**From:** Elliott, Stanice  
**Sent:** Thursday, November 02, 2017 11:27 AM  
**To:** 'Doug Gallagher'  
**Cc:** Bennett, Rick; Brissette, Renee C.  
**Subject:** Sun Valley Building 3  
**Attachments:** Submittal and CO Process.pdf

Based upon the information provided in your submittal received 10-26-2017, the above referenced plan cannot be approved for CO PERM until the following comments are addressed:

SUN VALLEY COMMERCIAL CENTER
BUILDINGS 3, 4 + 5
GRADING AND DRAINAGE PLAN

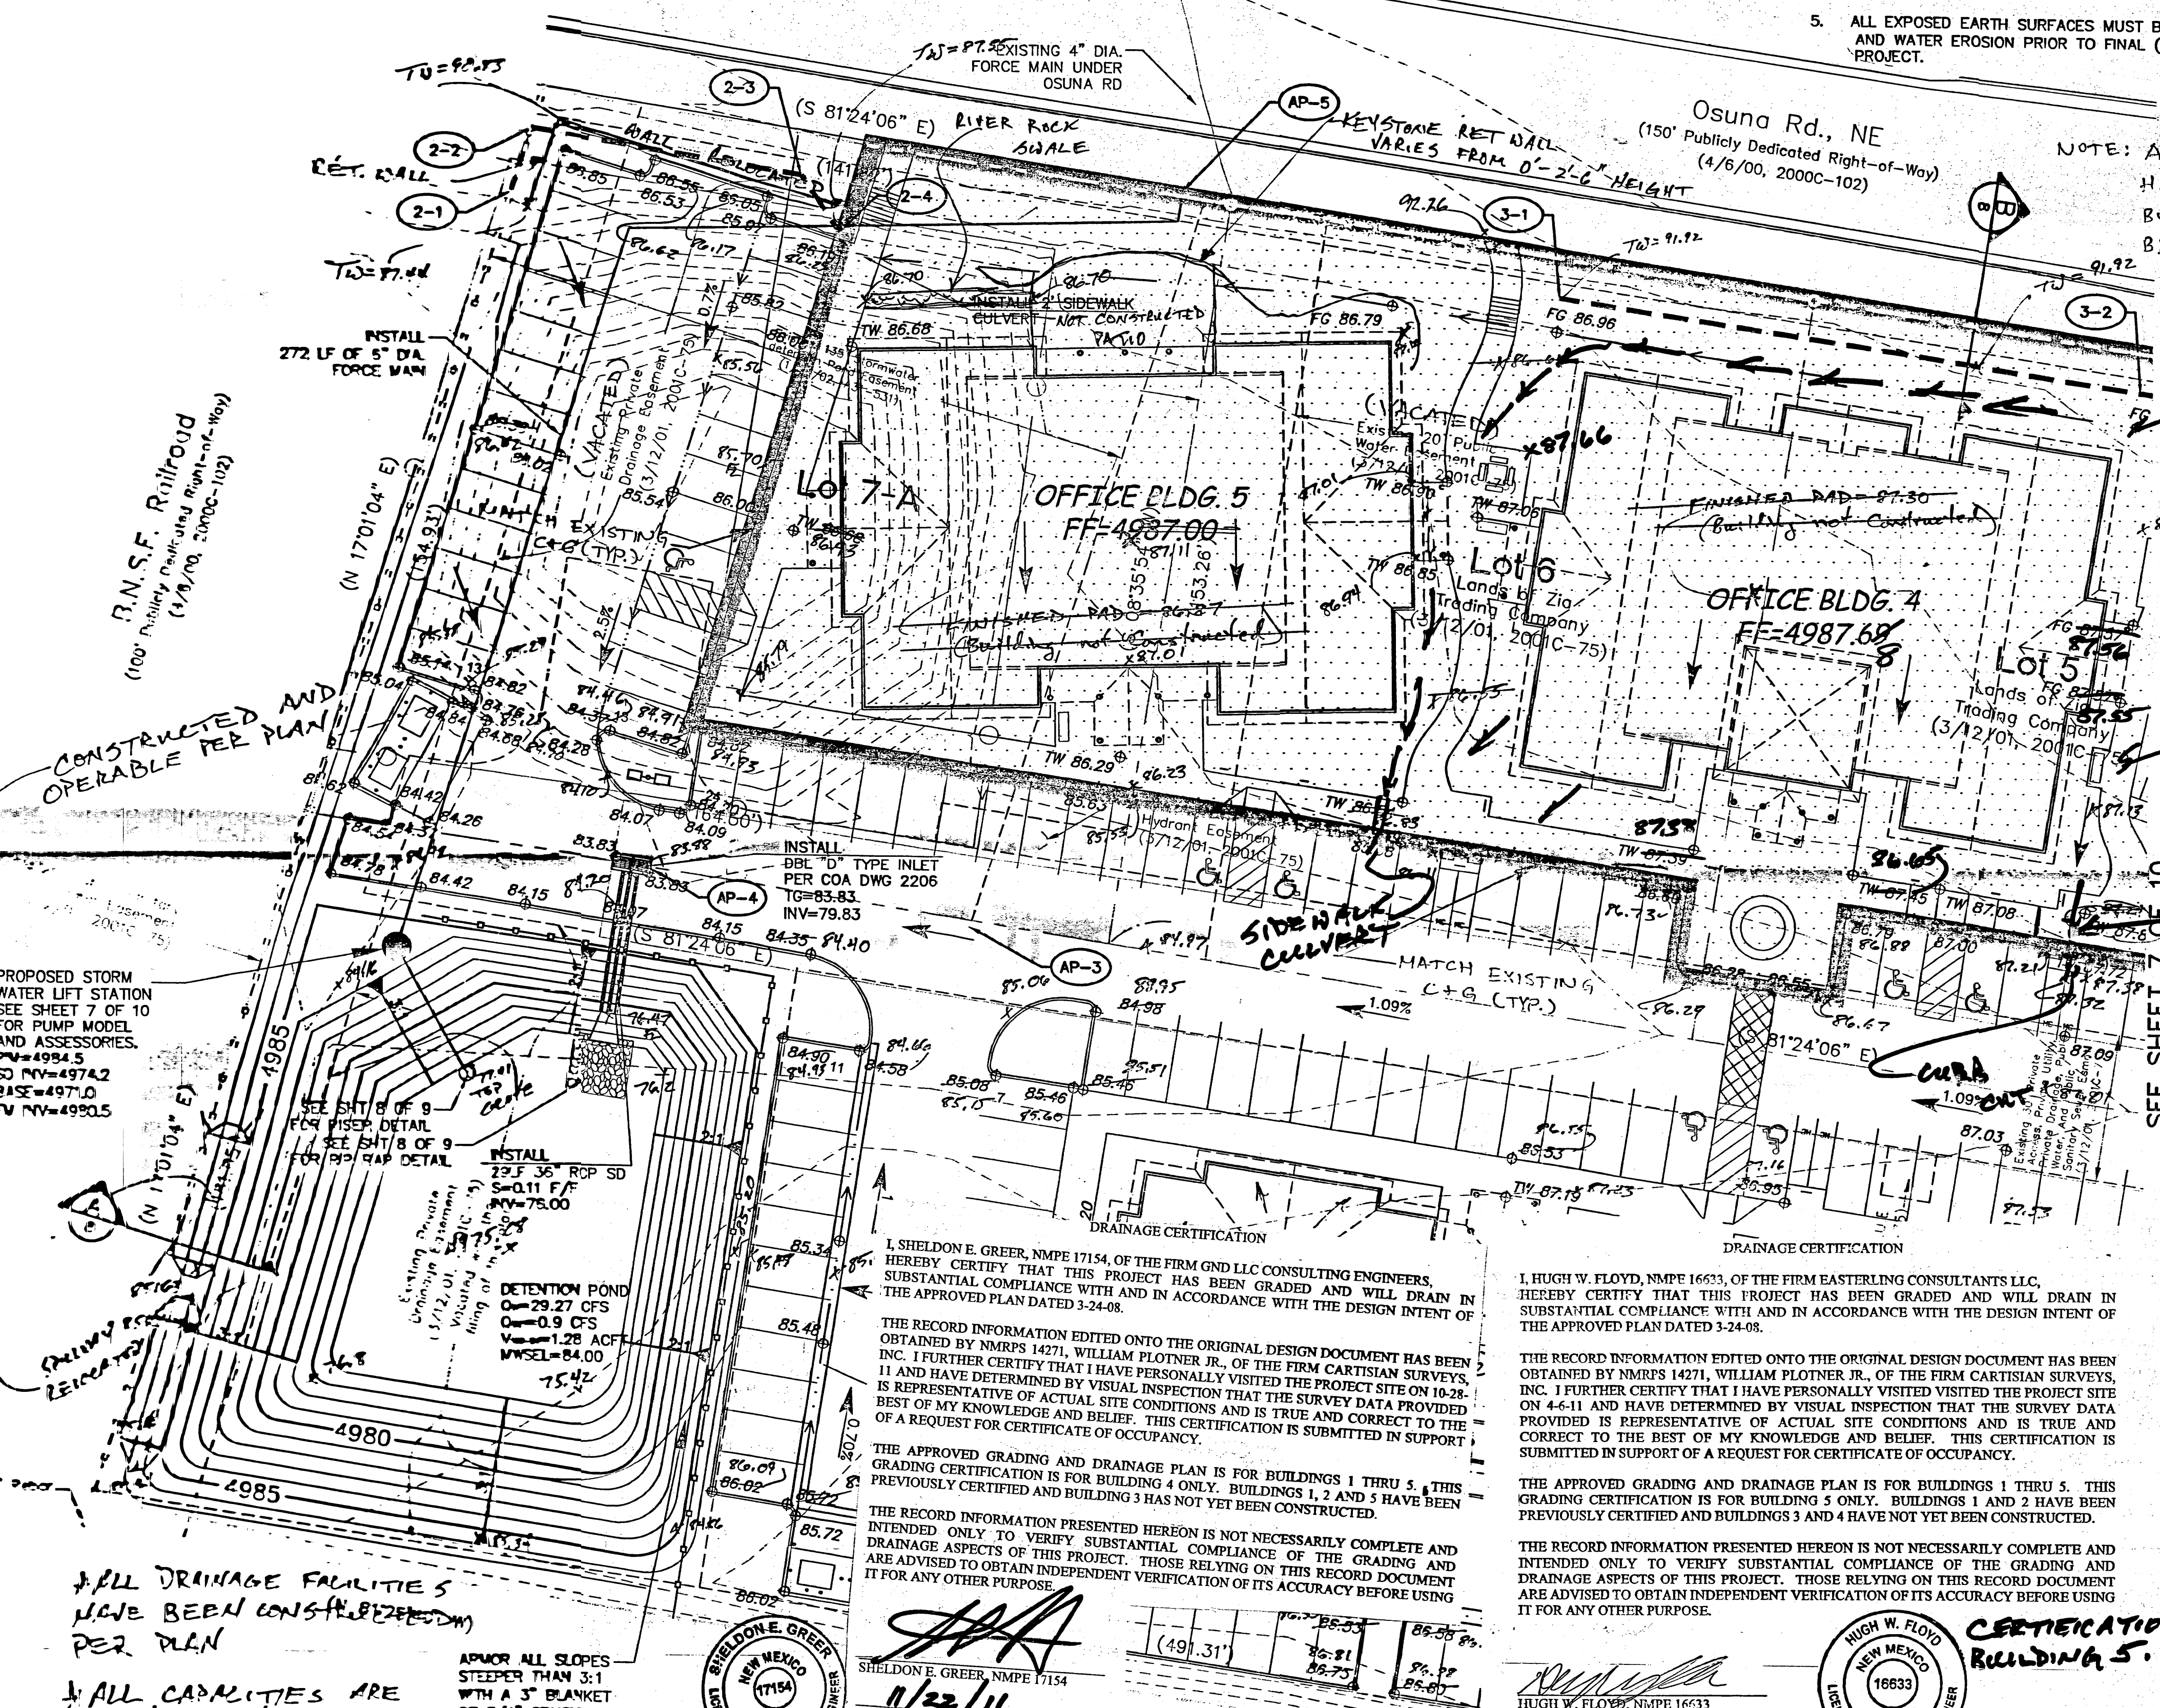
- The approved grading and drainage plan 2 of 3 with engineers stamp date of 10-16-07 must be certified by an engineer.
